**CITY OF ALBUQUERQUE
ADMINISTRATIVE APPROVAL (AA)- SITE DEV PLAN AMENDMENT
ROUTING & REVIEW SHEET**

APPLICATION #: 13AA-10291	PROJECT #: 1000418
PROJECT NAME: Legacy Church	
APPLICANT or AGENT: Lorenz Design & Consulting	
PHONE # and E-MAIL: 888-6088	
ZONE ATLAS PAGE: K-10	
ADMINISTRATIVE APPROVAL (AA) for:	☒ EPC CASE ☐ DRB CASE

LEGACY CHURCH WEST ACCESS ROADWAY DRAINAGE PLAN

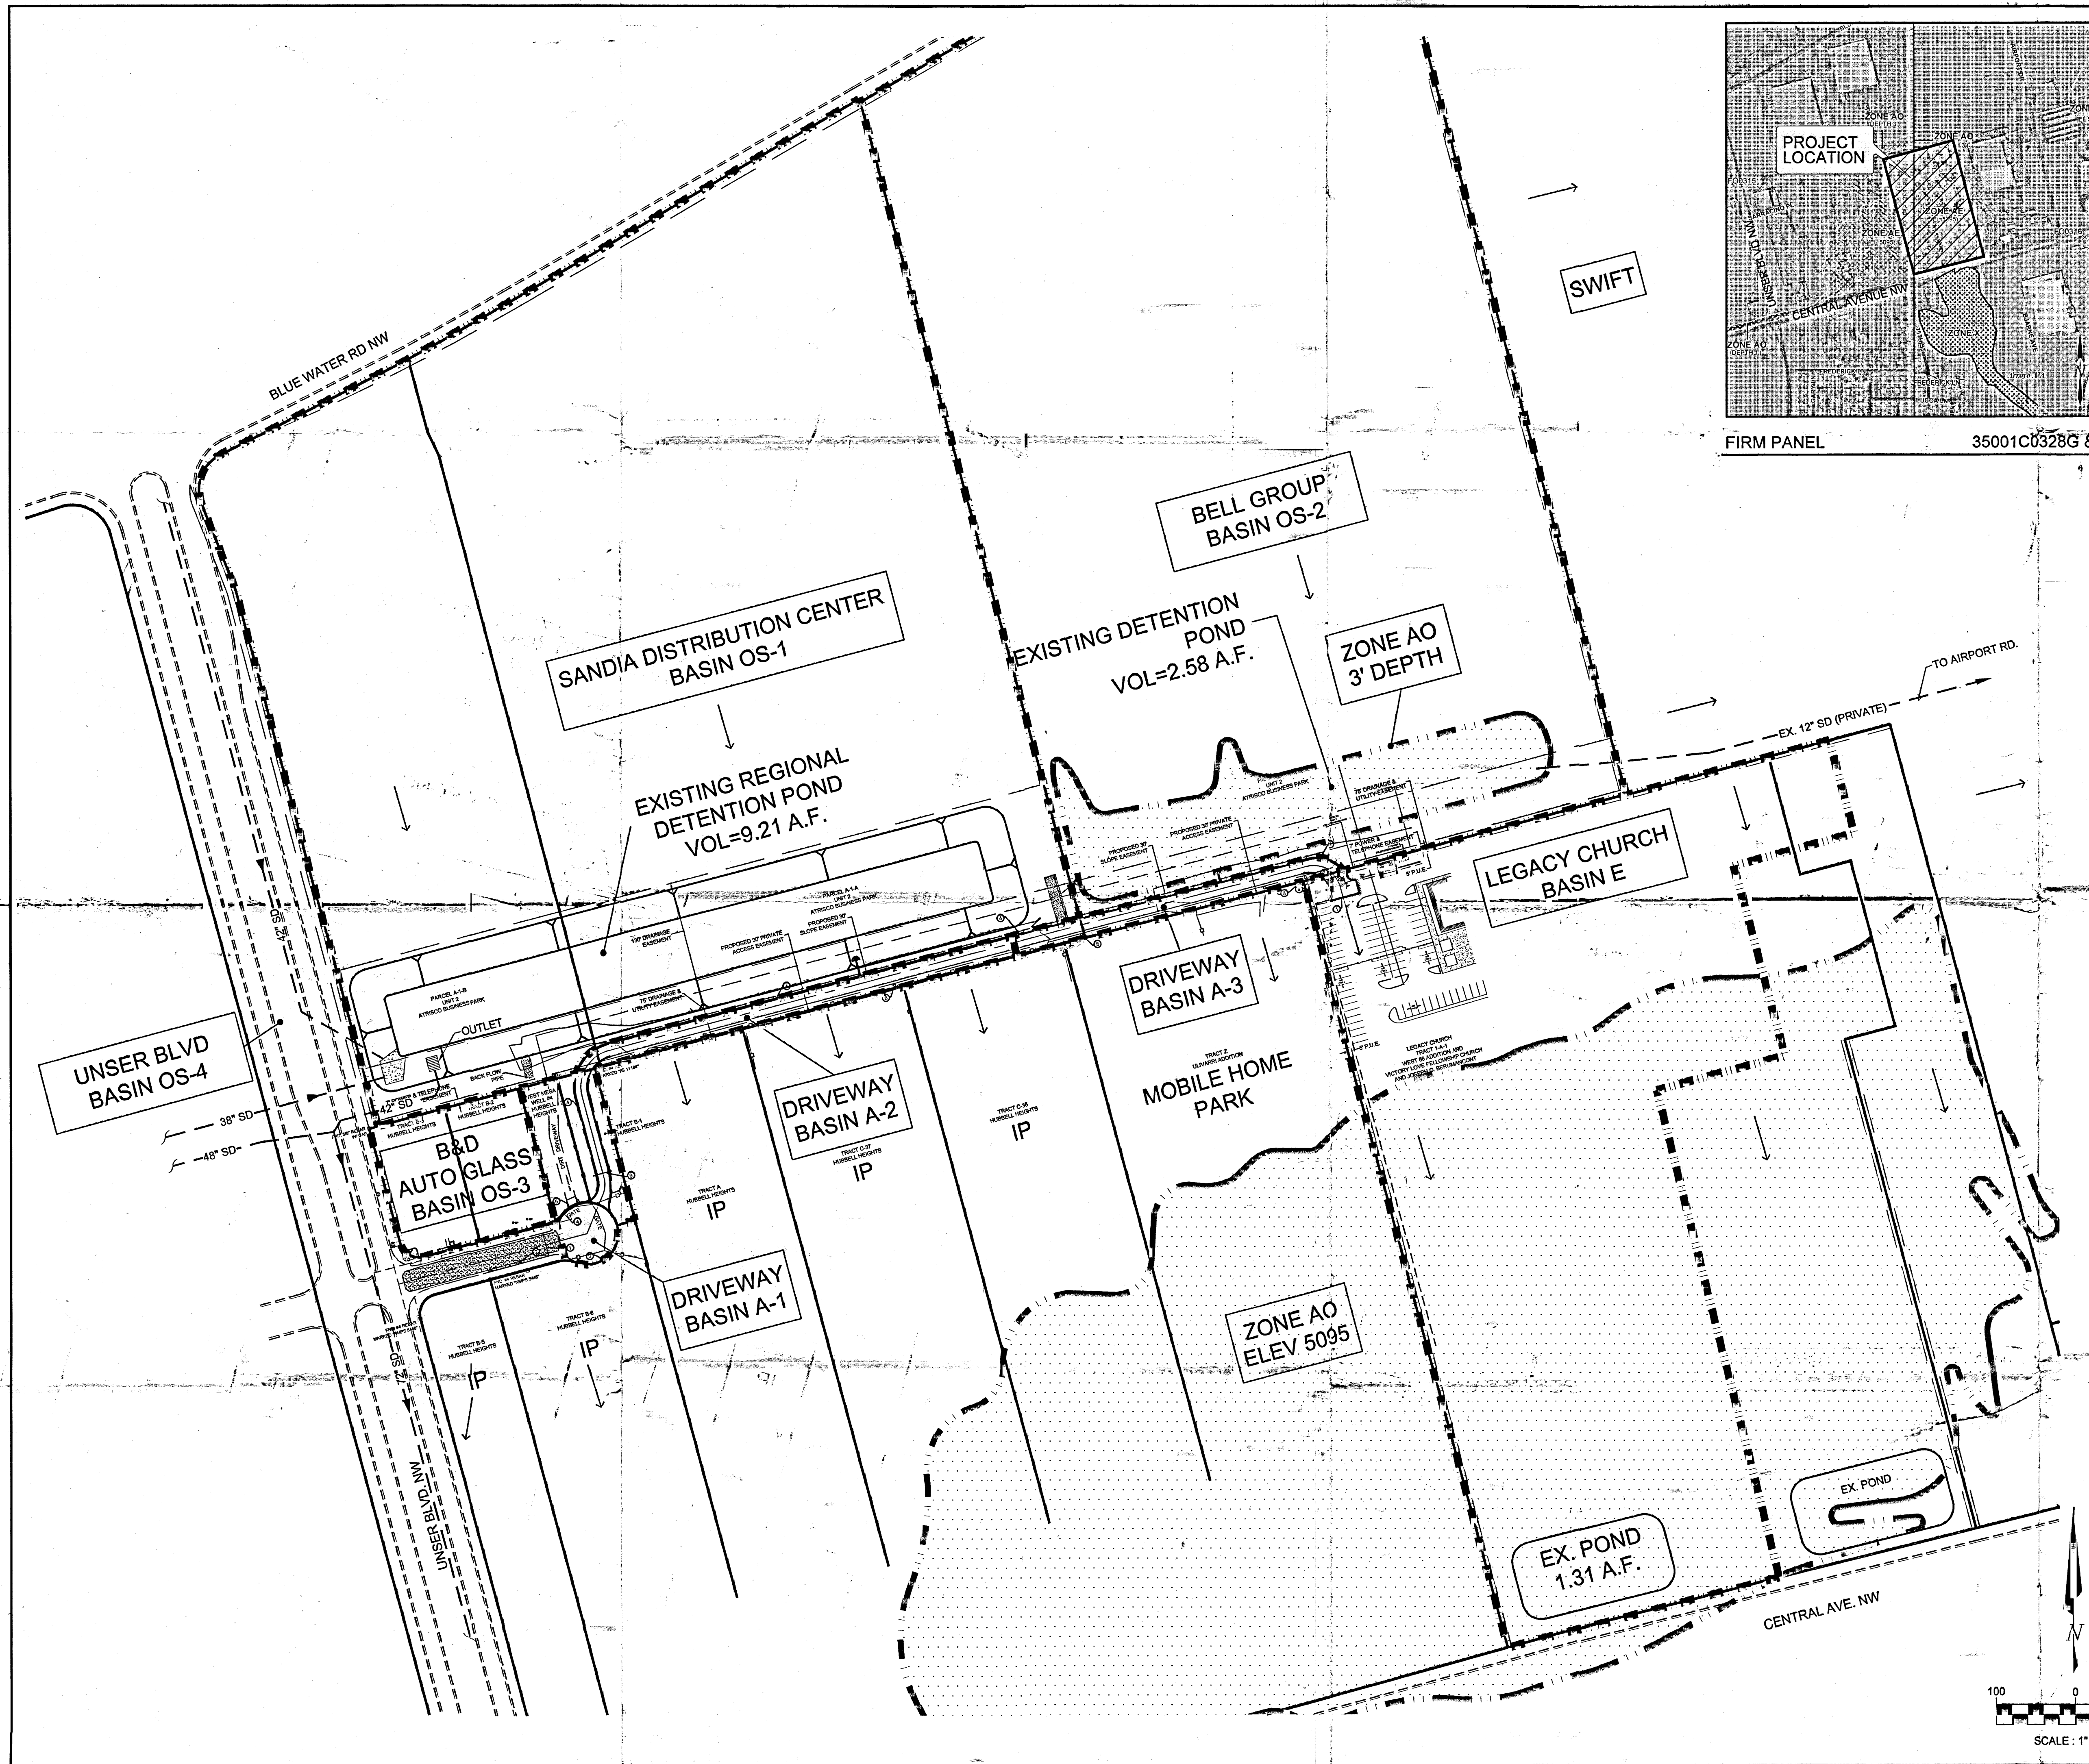
HYDROLOGY (505) 924-3986	DATE RECEIVED:
PLANS DISAPPROVED: GRO	DATE: 2-7-14
PLANS APPROVED:	DATE:
COMMENTS: ① Remove roadway from Public Drainage Easement (or Replat to CHANGE Drainage Easement away from Access Road. ② W.O. for Sarracino Cul-de-Sac must address Drainage ③ Comments on Hydrology Letter to Lorenz Design 2/7/14. Verify Pond sizes

TITLE:
LEGACY CHURCH
WEST ACCESS ROADWAY SITE PLAN

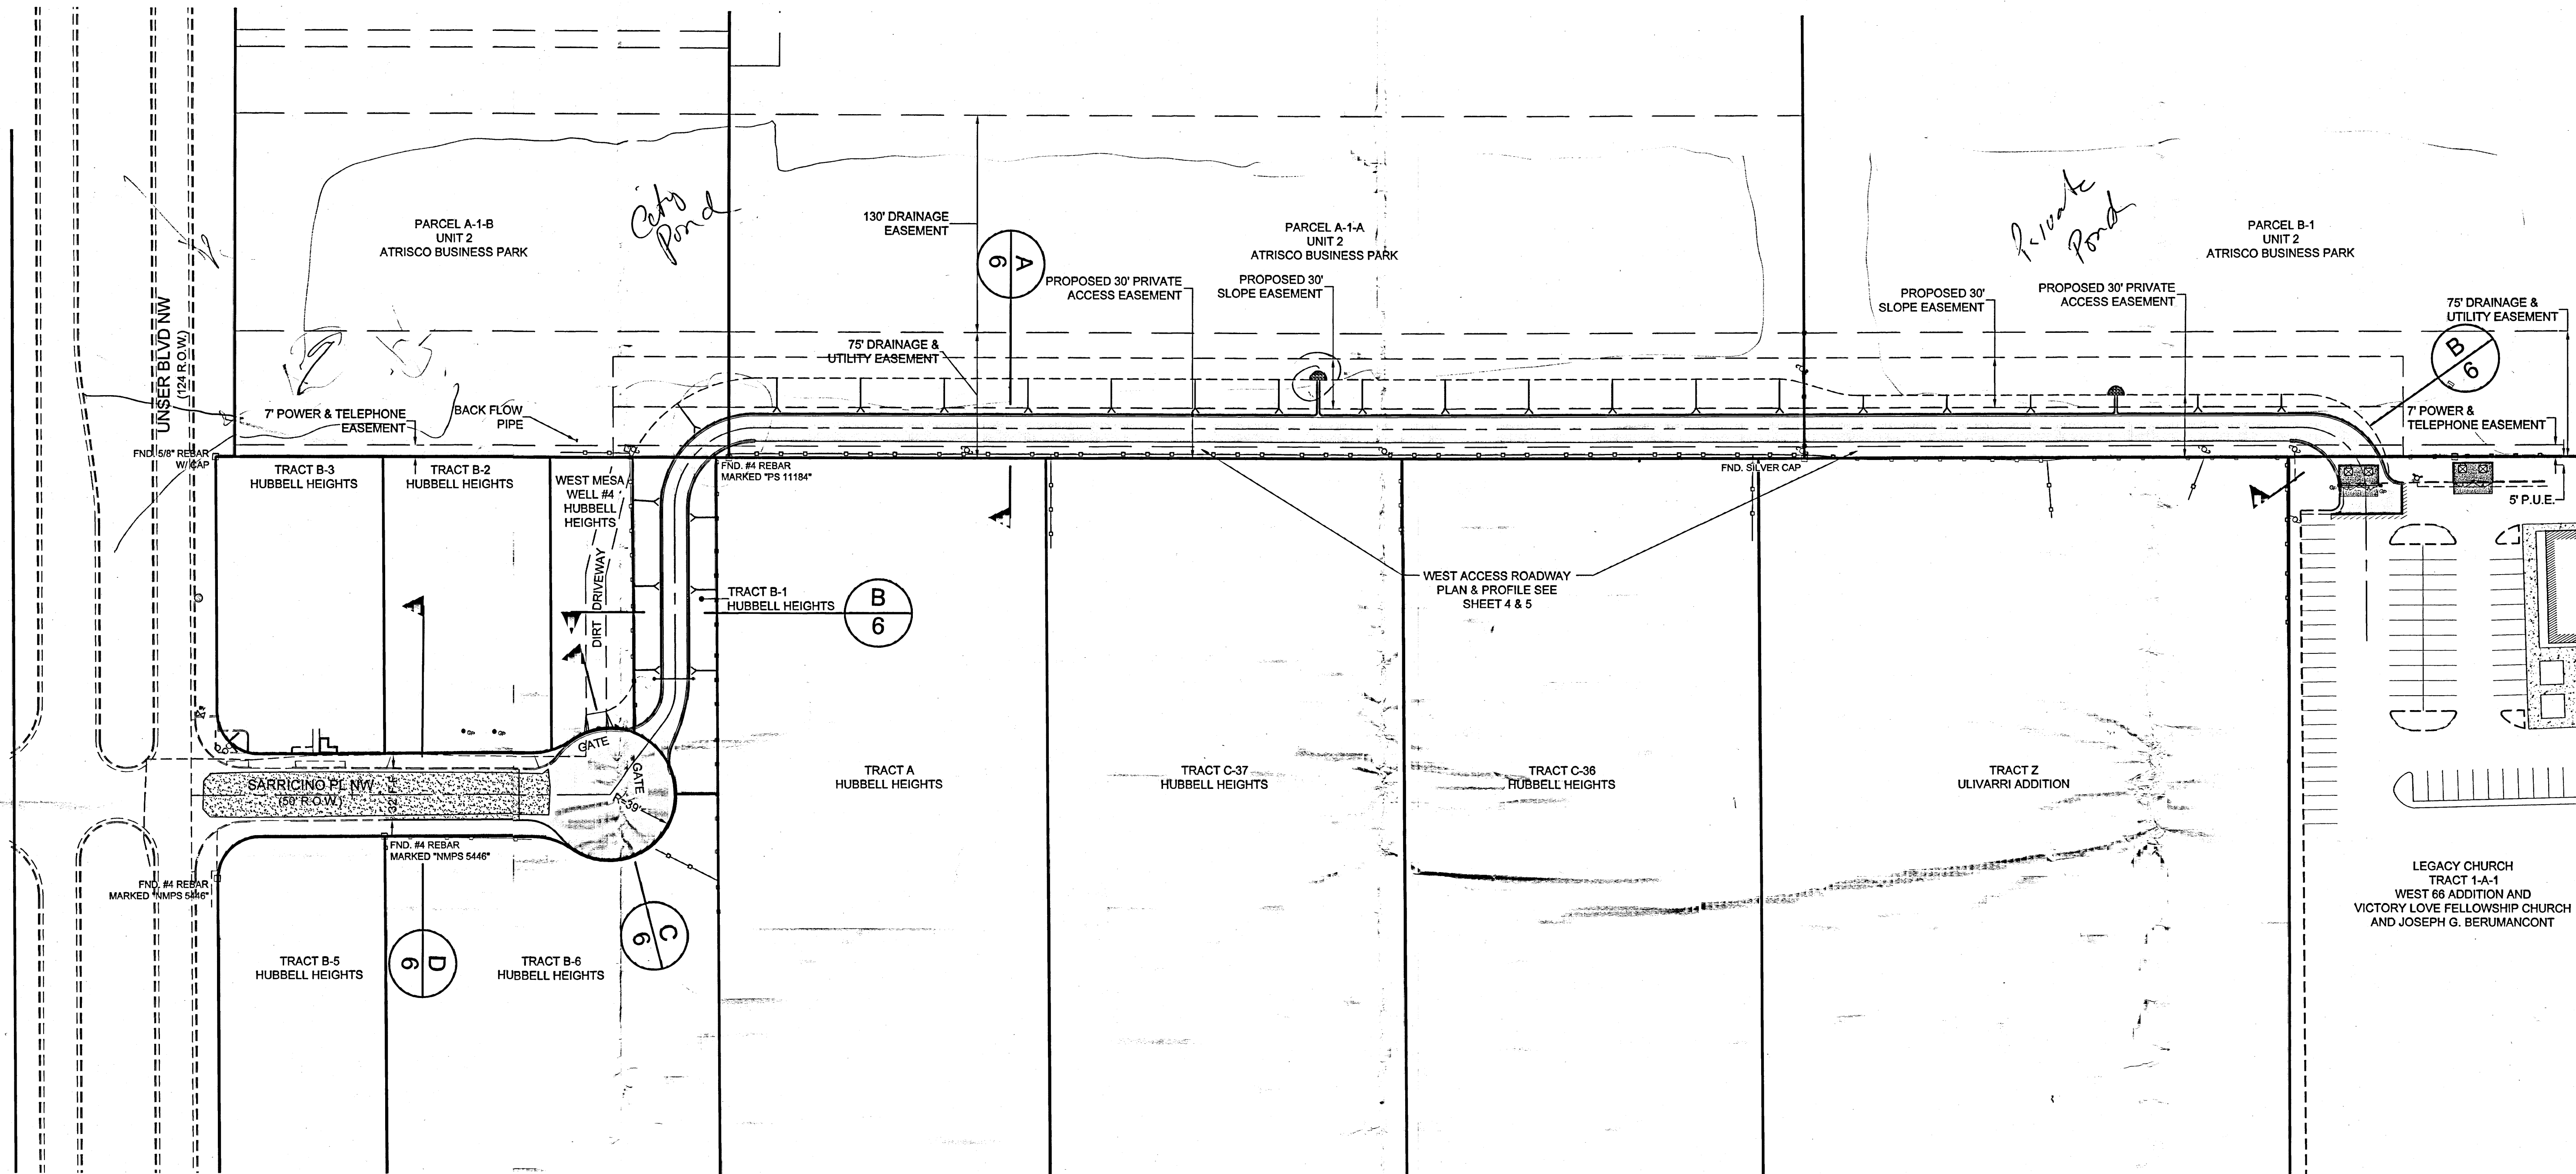
UTILITIES (505) 924-3989	DATE RECEIVED:
PLANS DISAPPROVED: AP	DATE: 12/11/13
PLANS APPROVED:	DATE:
COMMENTS: - Water line in Sarracino needs to be extended into cul-de-sac. Water line extension should continue into North South access road. The new public water line easement should be established in the east west access road.
